RESPONSE TO SUBMISSIONS – SSD-80814238

ROAD 1 DATA CENTRE, 1-5 KHARTOUM ROAD, MACQUARIE PARK

LEGEND

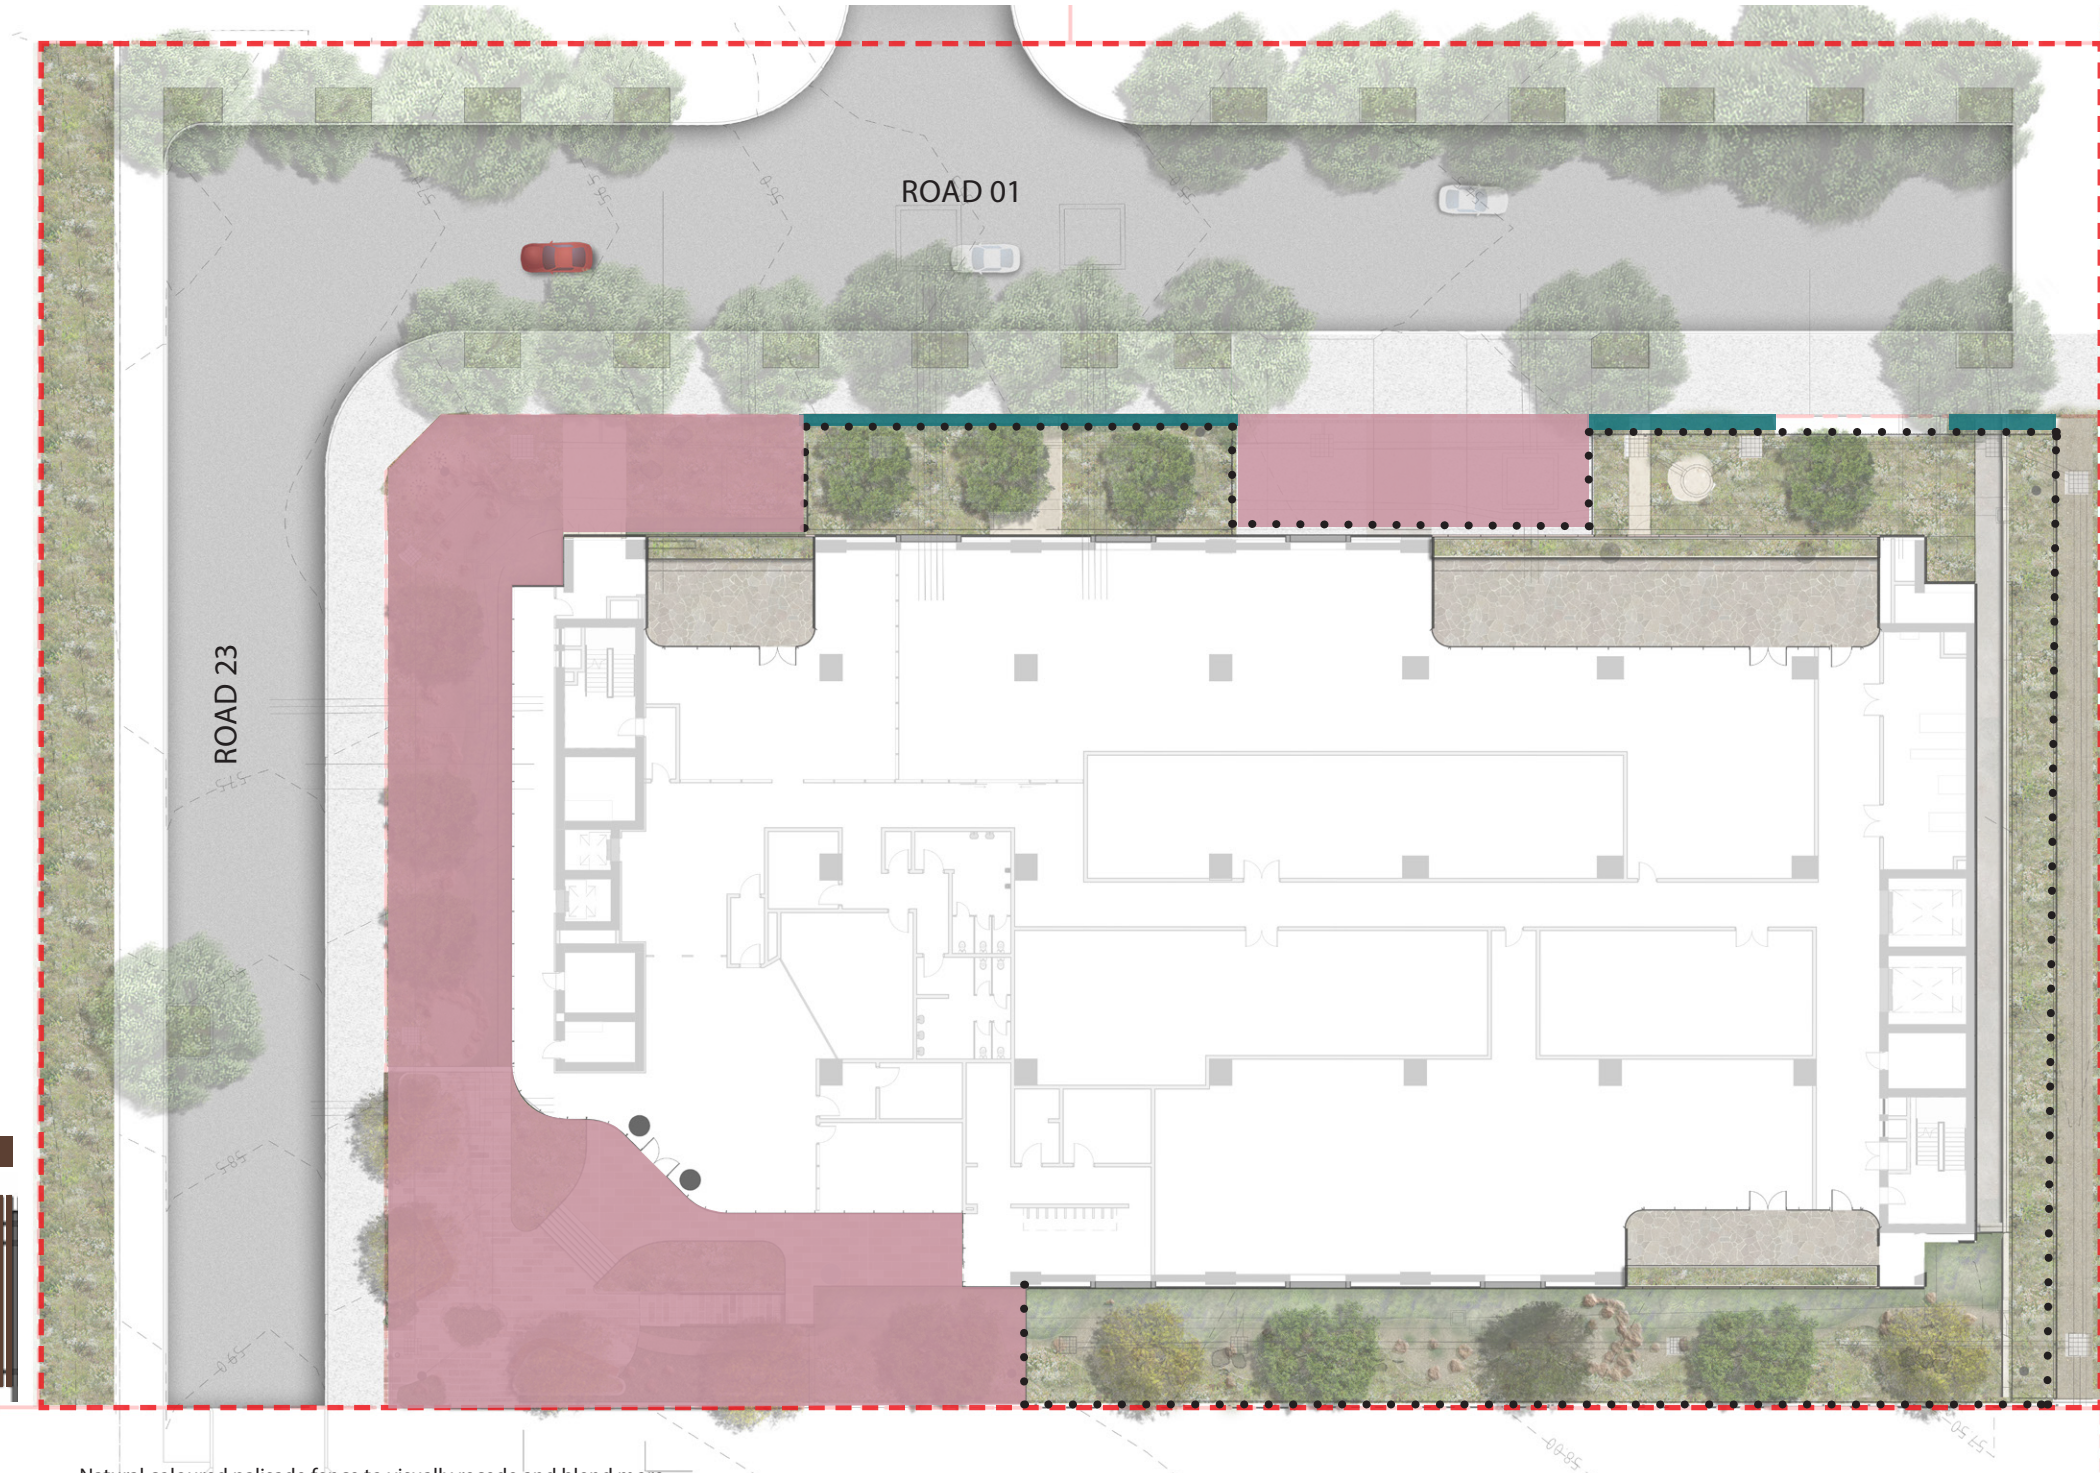
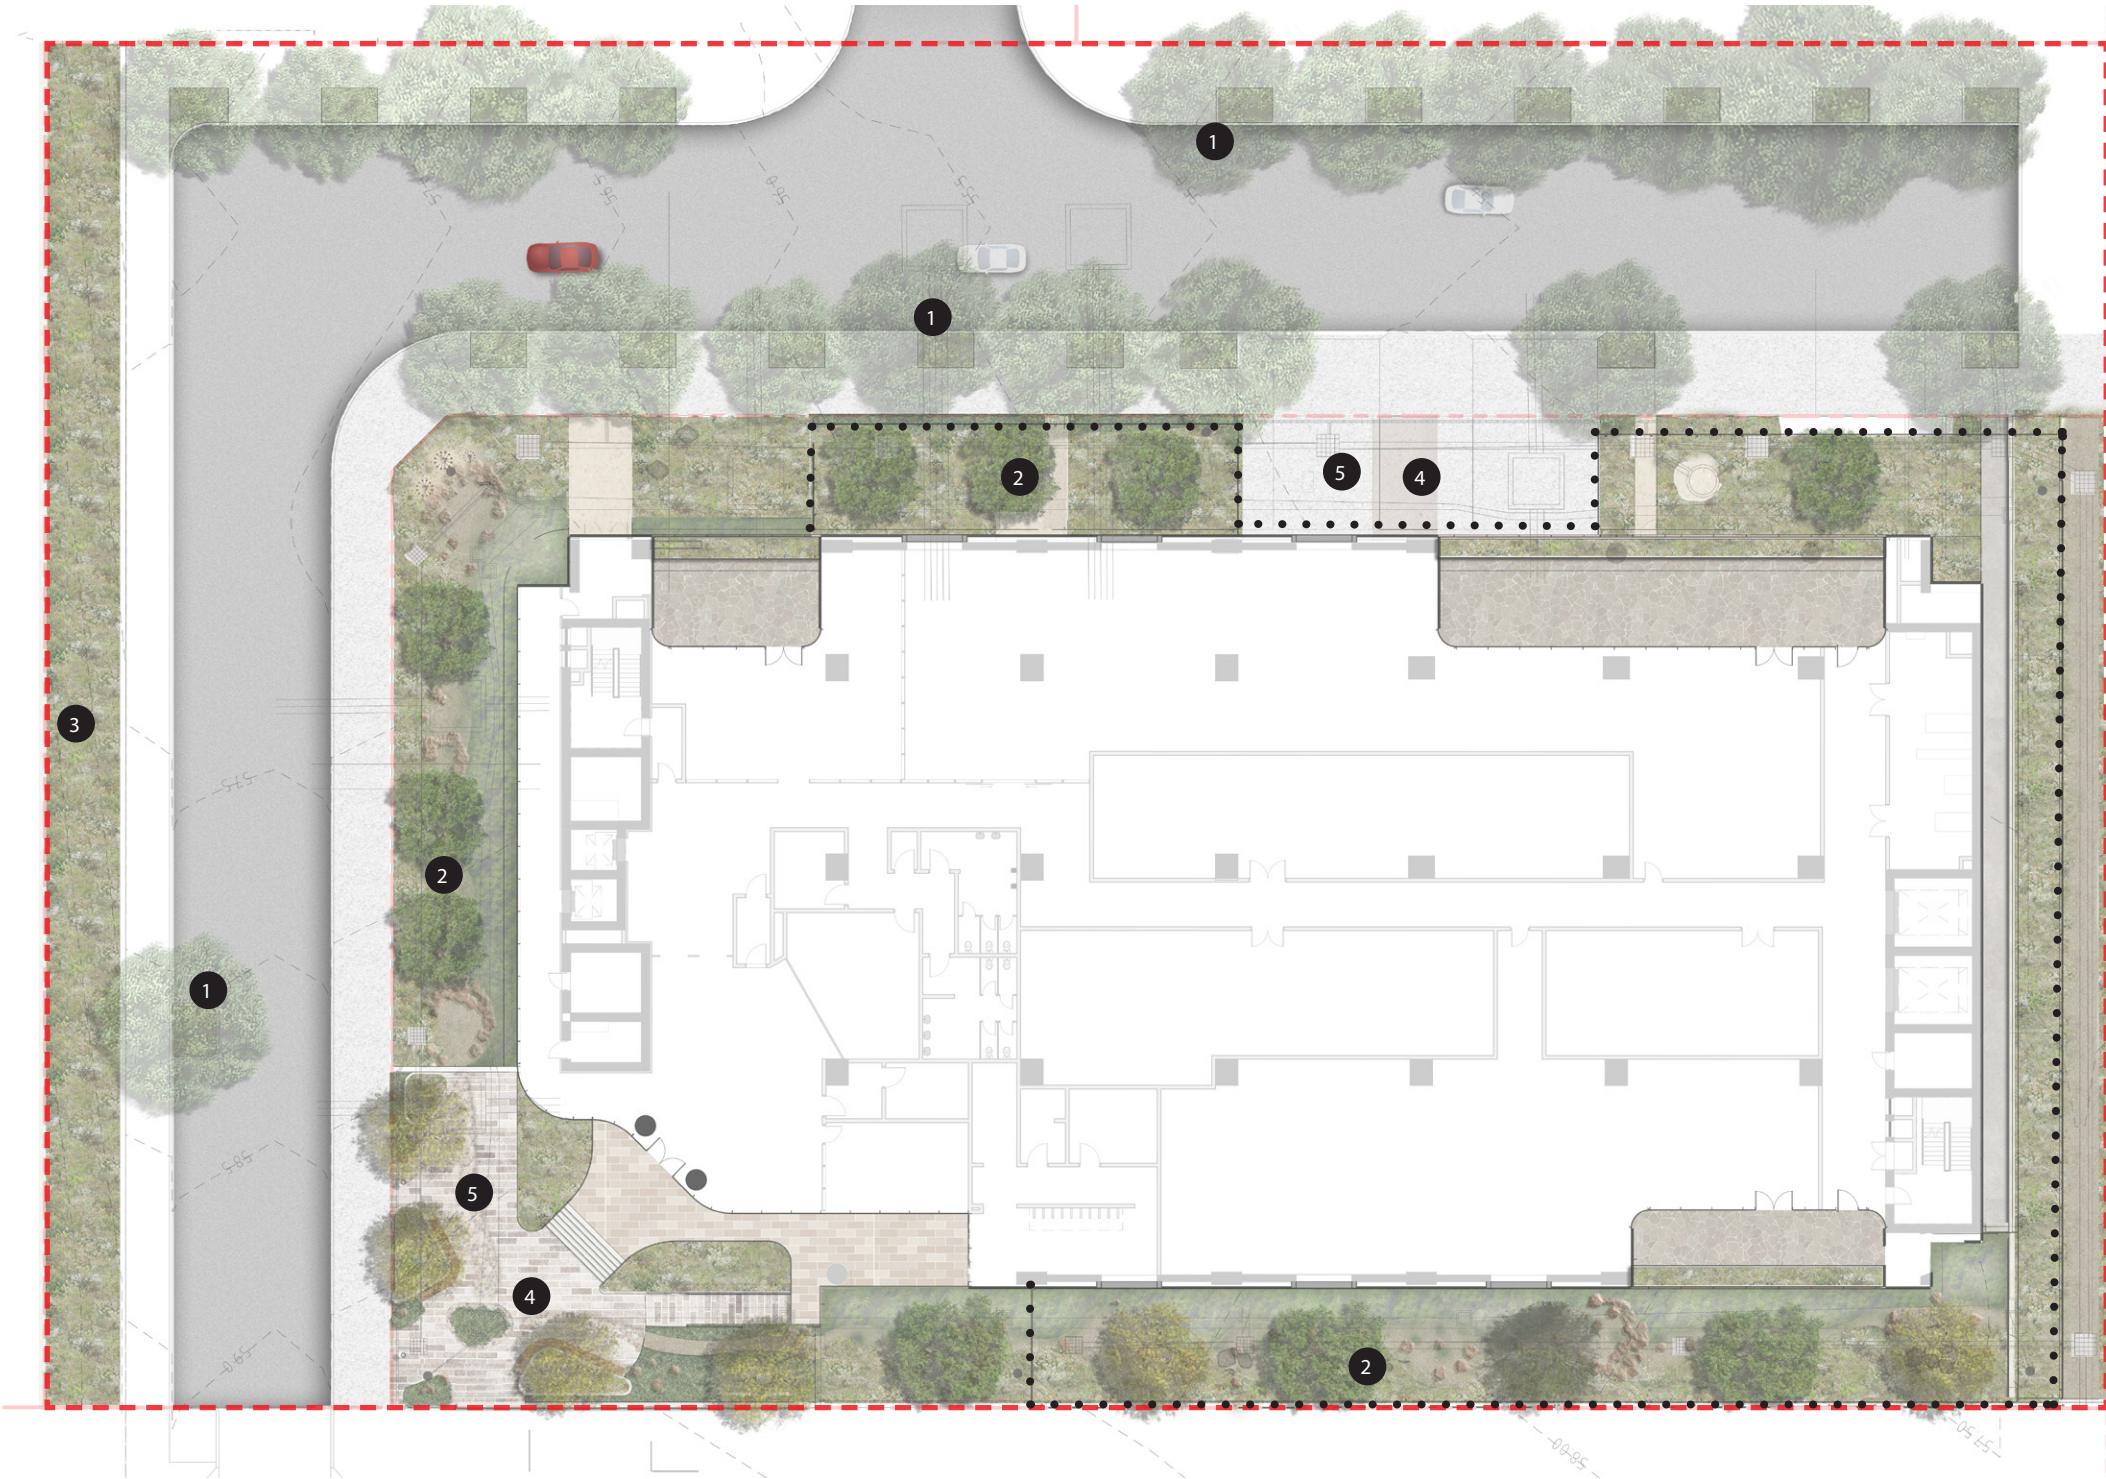
Summary of Issue Raised	Response	Supporting Document
<p>As previously outlined in advice from the Government Architect NSW (GANSW), the current black palisade fence design (FN01 2.4m High Security Fencing, Appendix E, Drawing No. MPARK2-GBA-BH-01-DR-A-0151) is not visually recessive particularly when viewed by pedestrians at an oblique angle, as the spacing and width of the vertical rails create the appearance of a solid black wall that visually dominates the streetscape.</p>	<p>The fence design has been revised to introduce alternating natural tones, including dark greens, browns and maroon, to provide tonal variation. Refer to the revised Landscape Design Report (page 31) provided at Attachment D. This approach reduces further the visual prominence of the fencing when viewed from the public domain while maintaining the required level of perimeter security. The overall extent of fencing has also already been minimised wherever operationally feasible, ensuring an appropriate balance between security requirements and streetscape integration.</p>	<p>Attachment D</p>

In response to a comment from GANSW, the design of the fence has been revised to introduce alternating natural tones, including dark greens, browns and maroon, to provide tonal variation and prevent the appearance of a singular solid black wall. Refer to the revised Landscape Design report provided at **Attachment D**. This approach reduces the visual prominence of the fencing when viewed from the public domain while maintaining the required level of perimeter security.
